Review of the Applicant's Technical Note [[REP3-038](#)].

The Applicant's response to the ExA request at [ISH2](#) for a Technical Note was submitted at Deadline 3. The narrative and figures are mostly from previous submissions, although there are new details and insights.

Figure 2. Illustrative MWh/day across a typical year for a 480MW dc scheme (based on 1990 weather data)

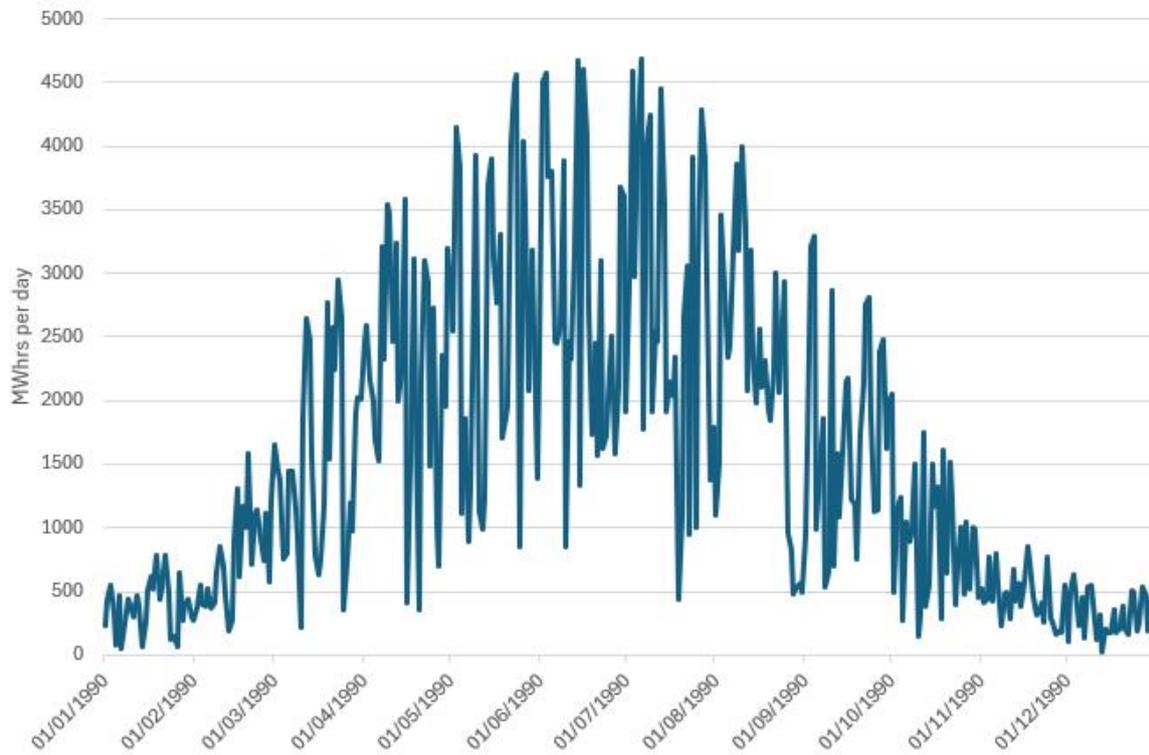
- 2.1.4 The new graph [Figure 2, 4.1.6] based on 1990 meteorological data is a surprising addition. As PVsyst explains, you cannot select a particular year for meteorological data: meteo files are compiled by amalgamating data from ten or more years. (And, why would you choose 1990?)

A handy feature of PVsyst though is the ability to download data files into Excel, where you can re-annotate graph axes to suit your documentation requirements.

If, like me, you lack experience with PVsyst, you might not be aware that

The year 1990

In PVsyst, we have adopted the convention to label all data which don't correspond to really measured data at a given time as 1990. This is the case, namely, of all synthetic hourly data or TMY data files.
